Application No: Y/123/21/PL
Site Address: Land to the south of Ford Lane and East of North End Road Yapton BN18 0DS
Description of works: Variation of condition imposed under Y/82/20/RES relating to condition 1 - plans condition.

Thank you for your internet representation made on 8th October 2021 which has been recorded as an objection with the comments as follows:

**Title:**  
PLANNING LAYOUT

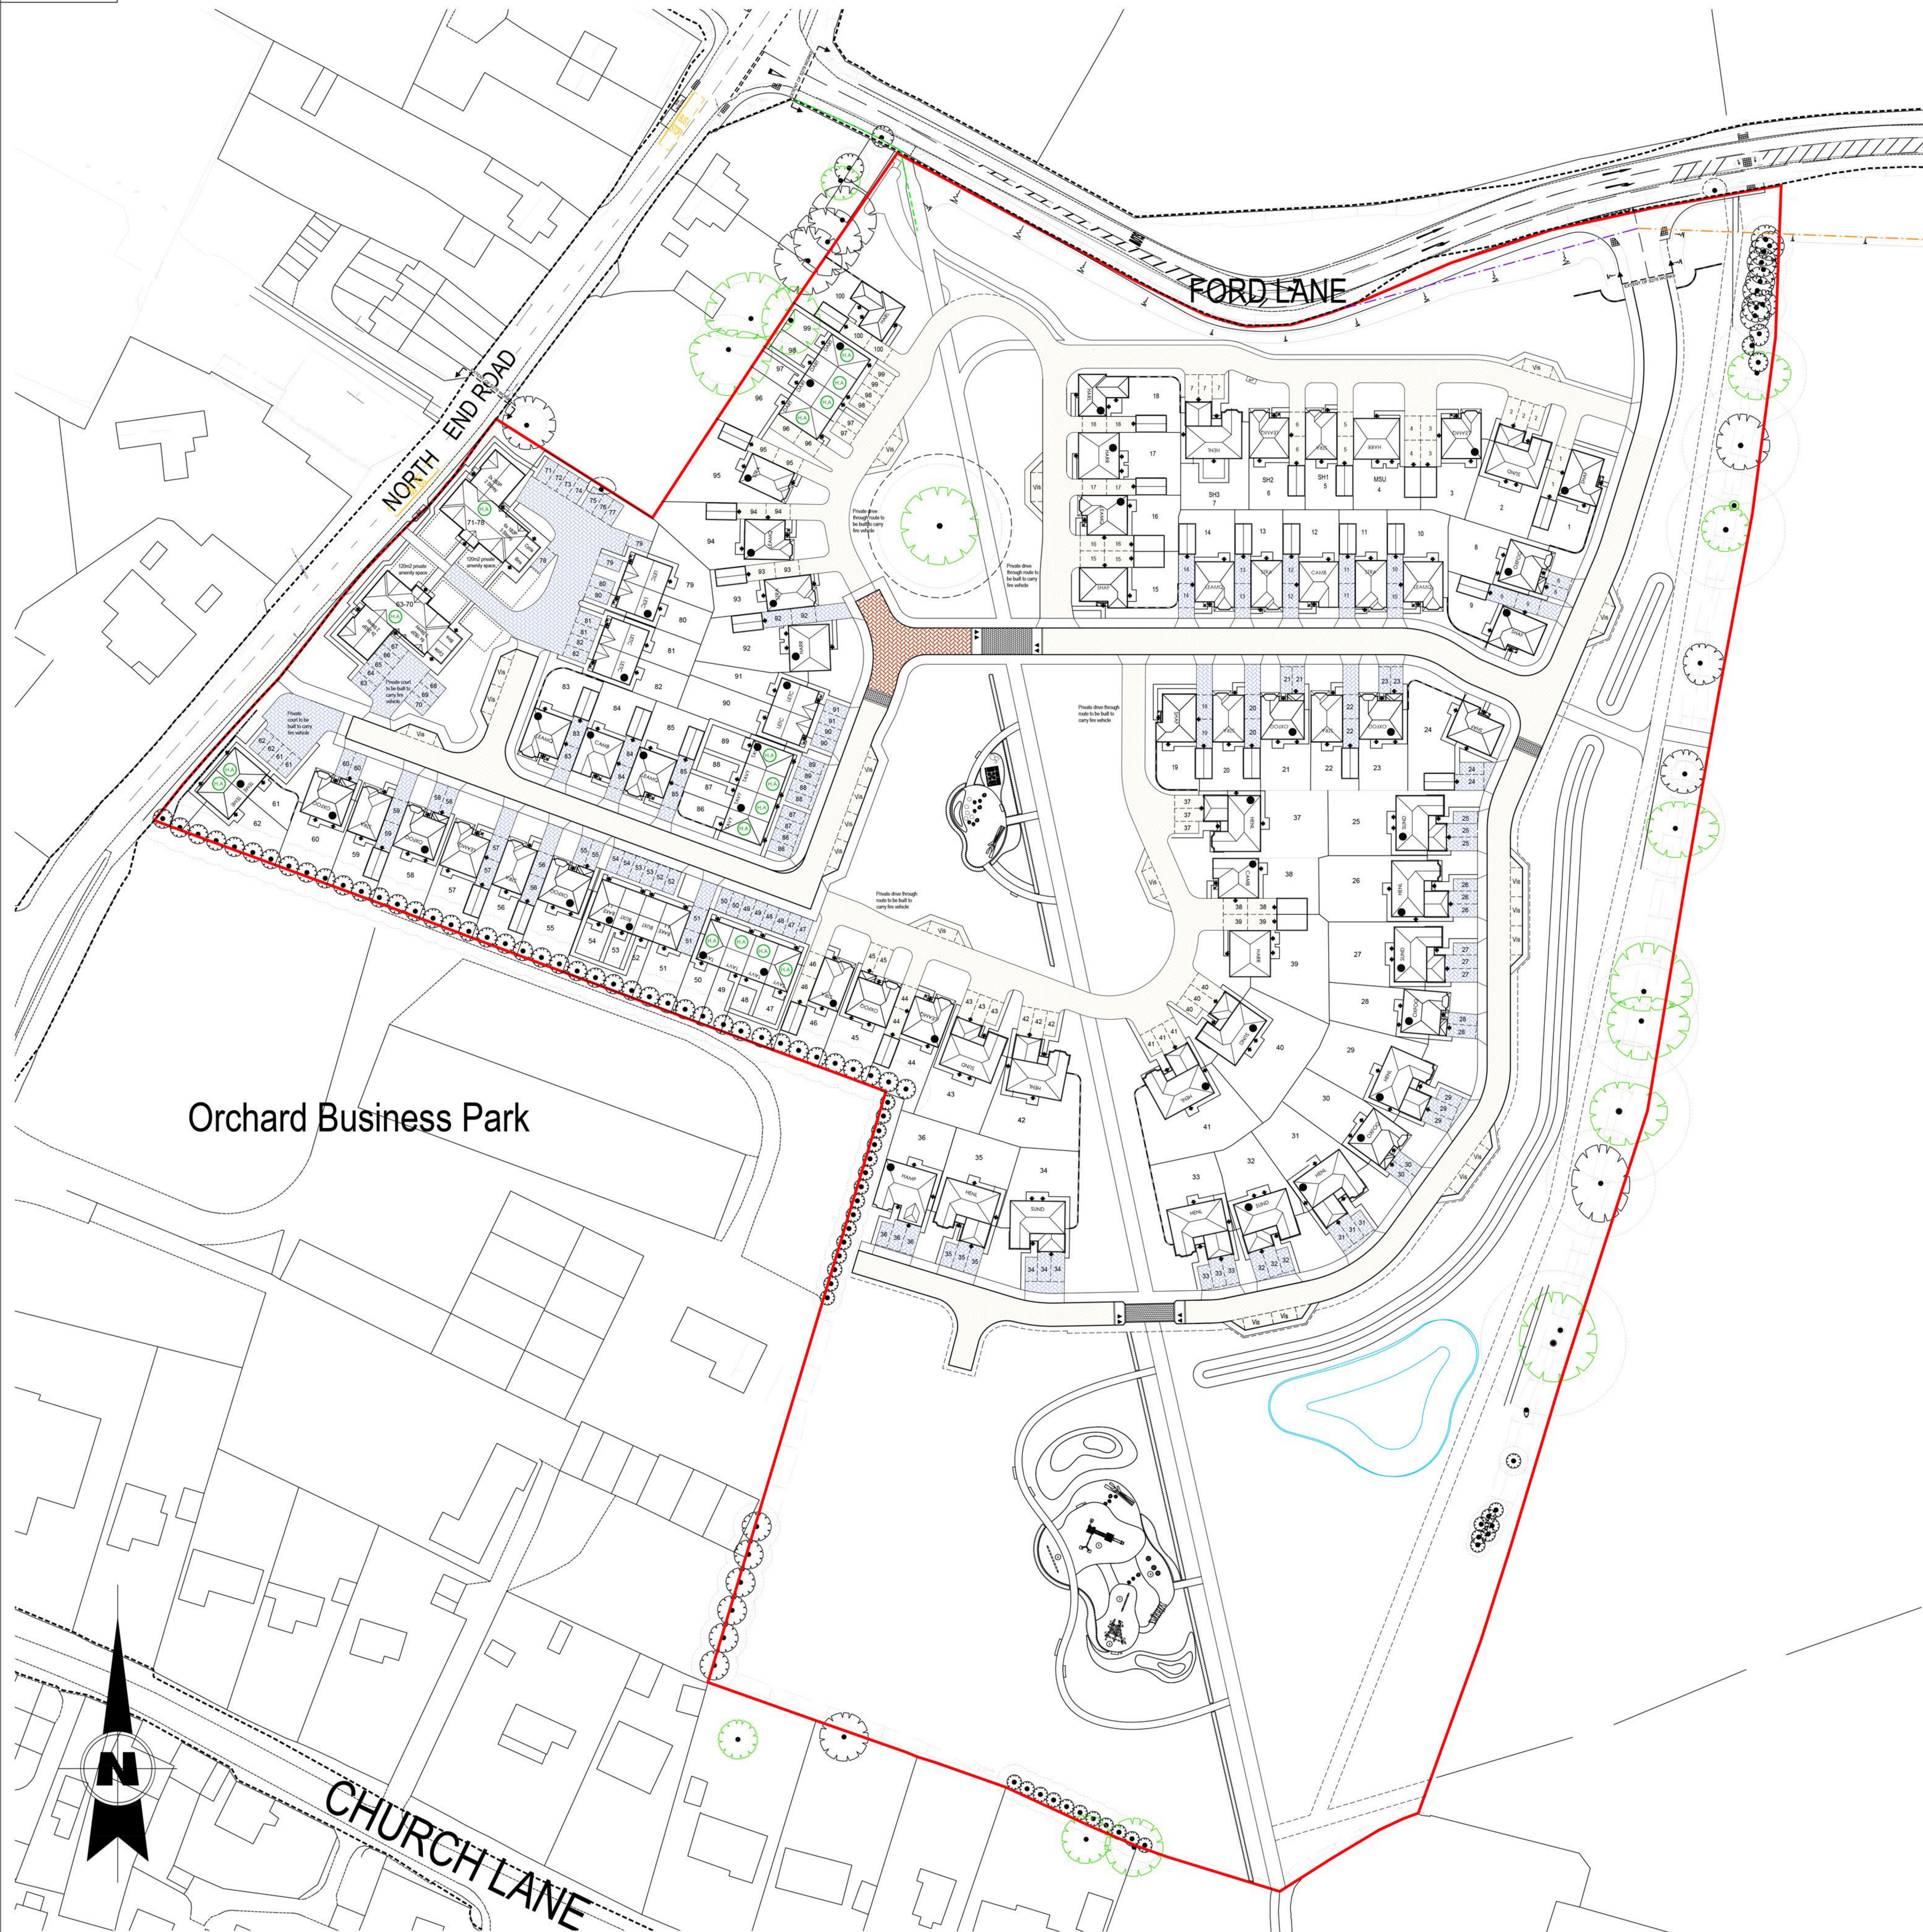
We would like to be assured that the open area to the southwest cannot be accessed by vehicles either vans dumping rubbish, cars parking, travellers or joyriders. The previous proposal was to bollard the footpath but now there is a large open area - turning circle?- which creates access to the green space. Can you please ensure the design can restrict vehicular access to this open space.
